SUBJECT: Engineering Review Comment
Mountain View Electric Association Inc. (MVEA)

Project Name: Waterbury Filing 1 – Final Plat

Project Number: SF237

Description: Proposed development of 198 residential lots and 11 tracts on approximately 62 acres located north of Stapleton Rd. between U.S. Highway 24 and Eastonville Rd. in Township 12S, Range 64W, Sections 28, 29 and 33.

WATERBURY FILING NO. 1 FINAL PLAT

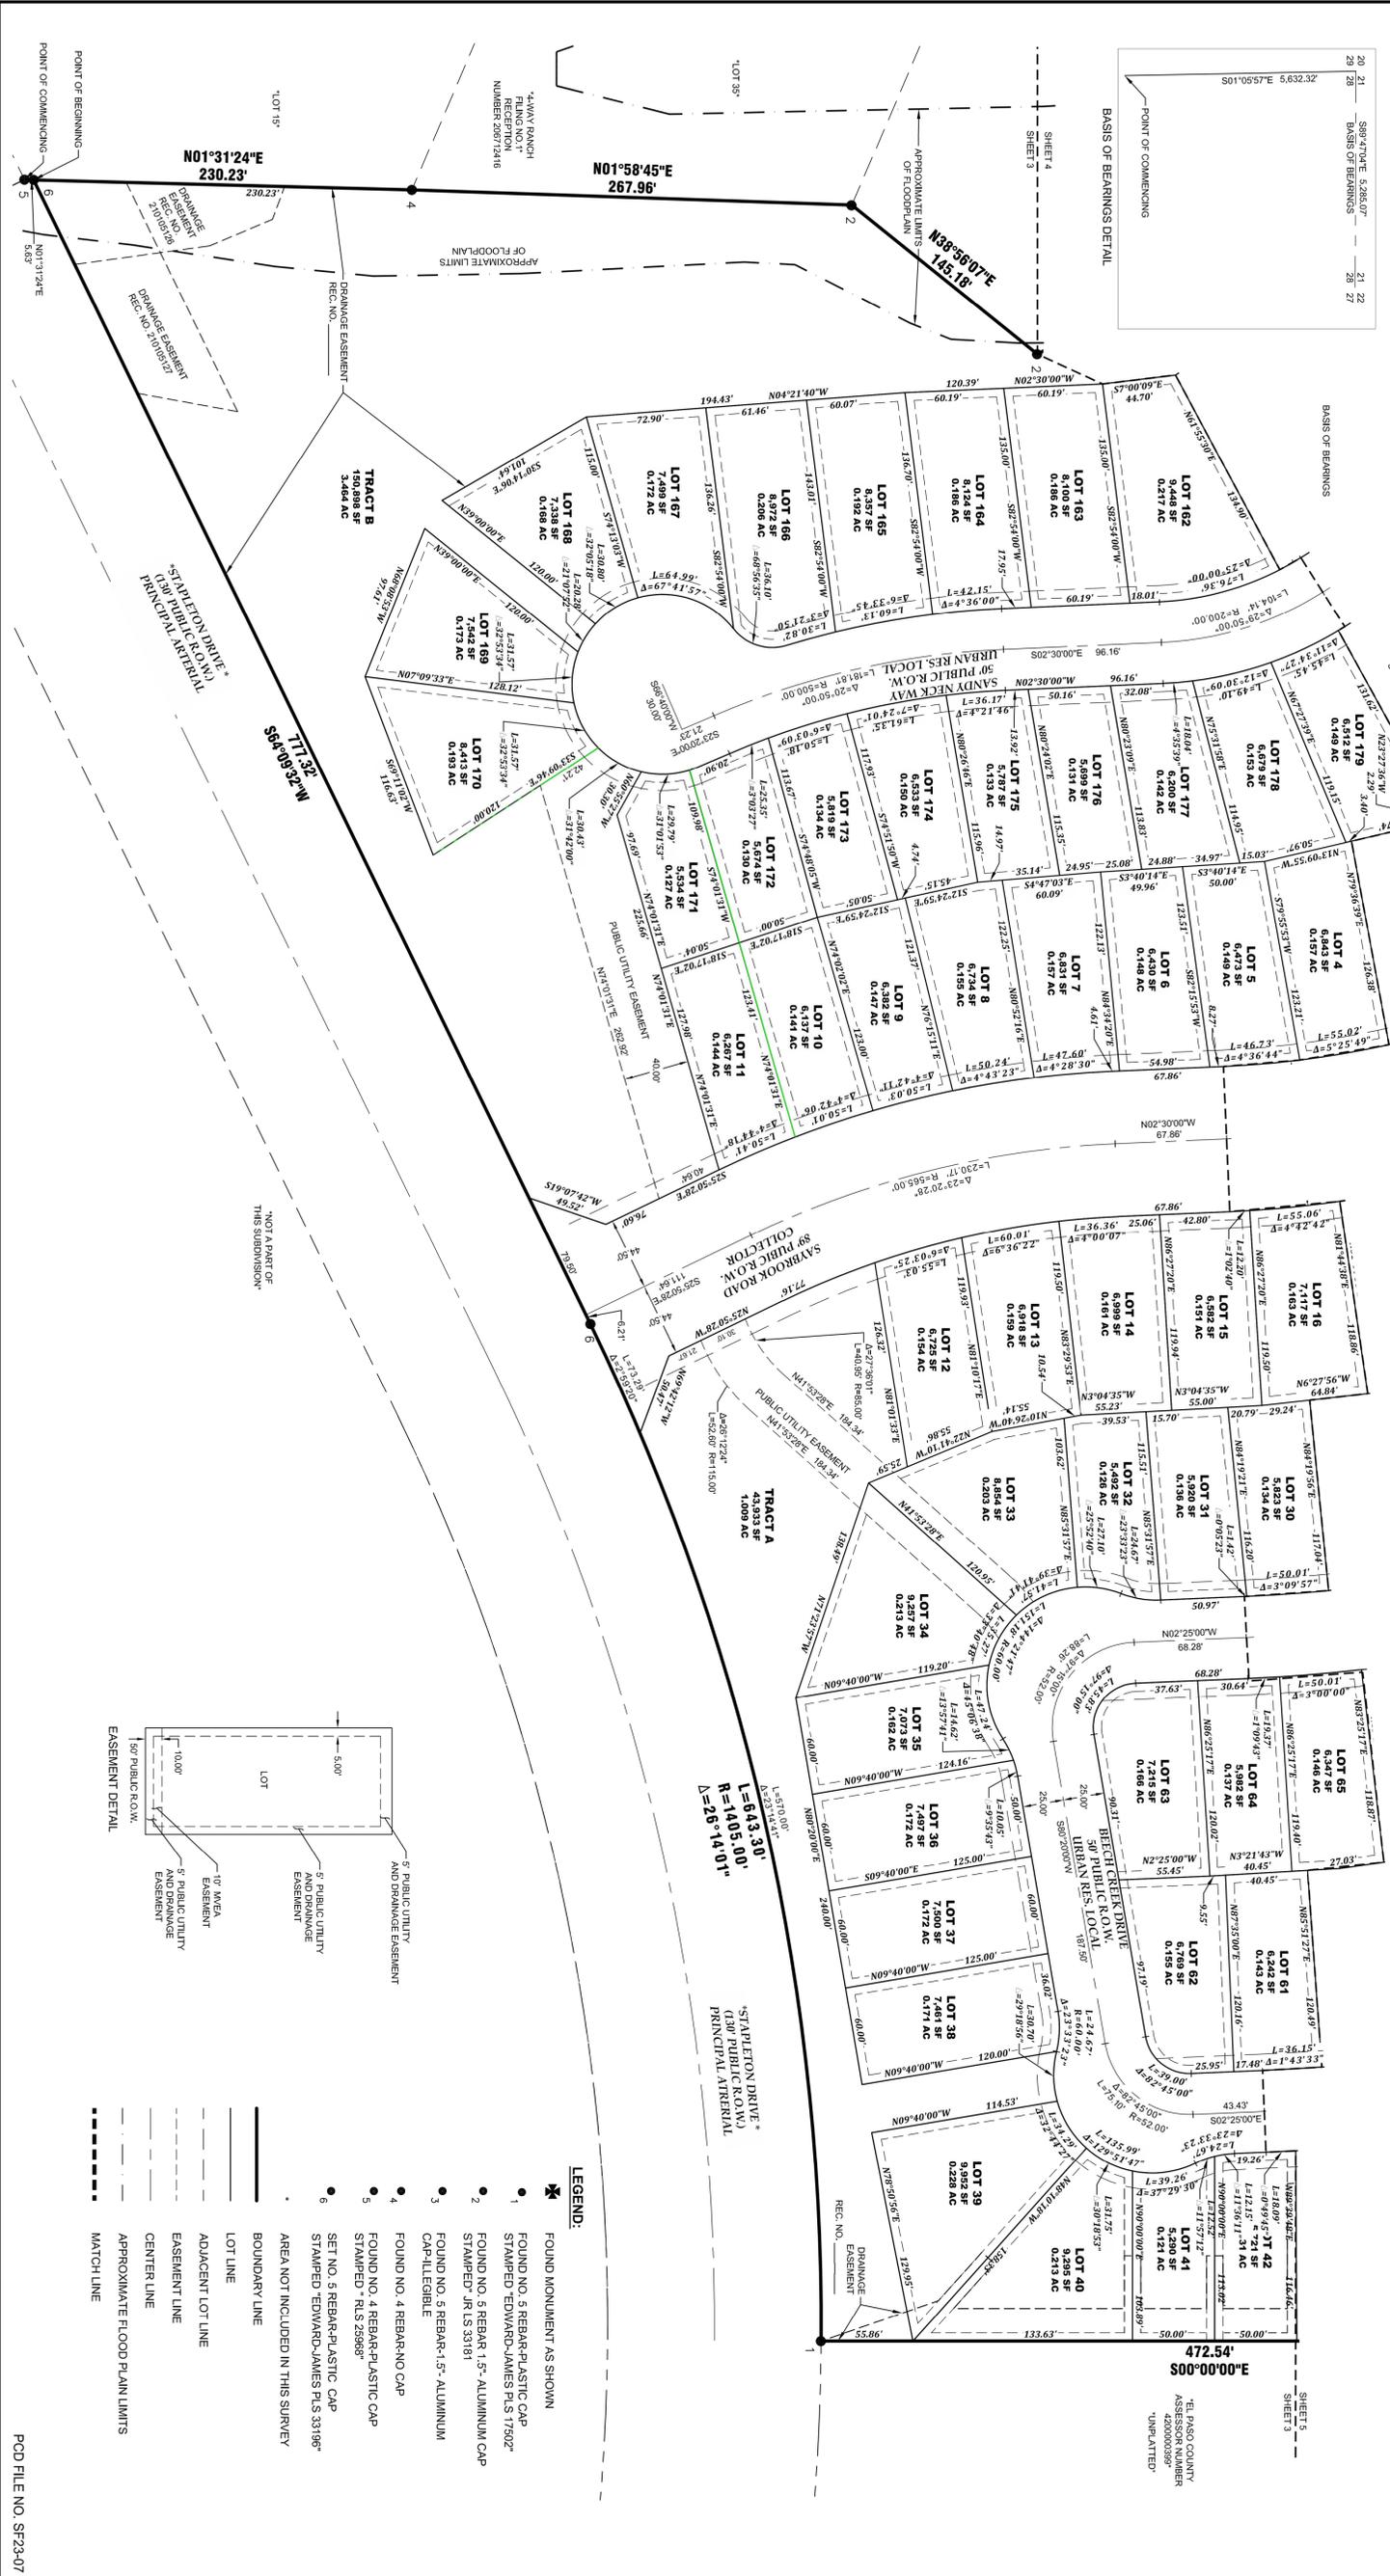
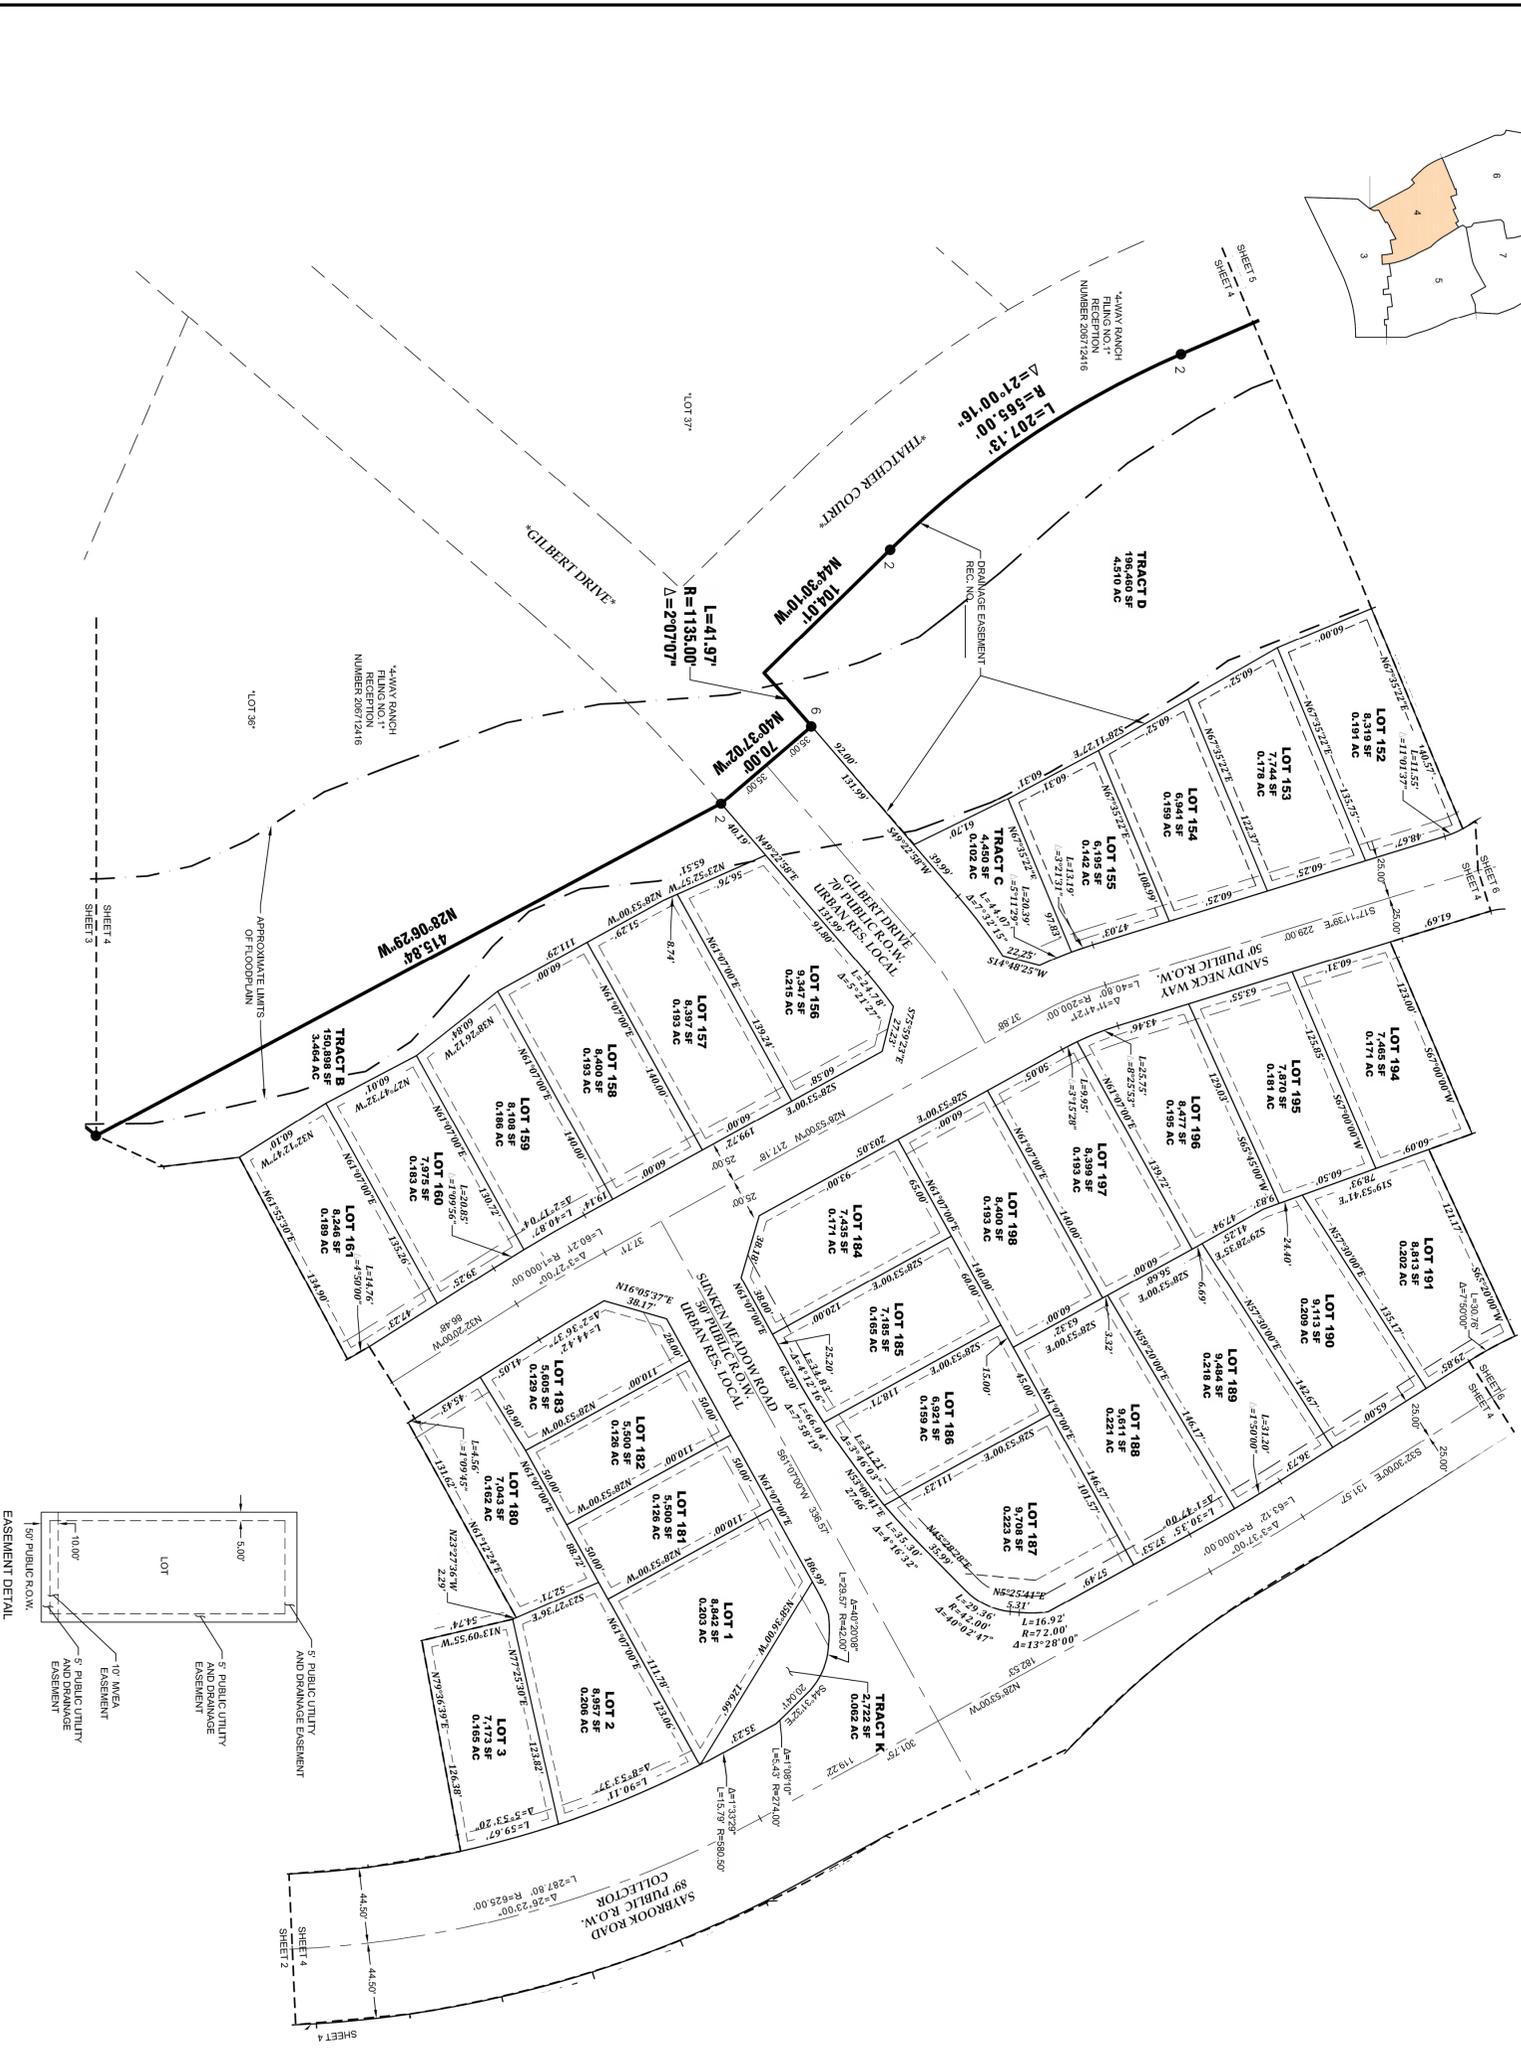
MVEA approves the ten (10) foot front lot utility easement in addition to any public improvement easements, as shown, and all tracts include easements. Please include "Utilities" under all tracts in the Tract Table. MVEA also requests the platting of MVEA's existing facilities with easements on the plat. Additional easements may be required.
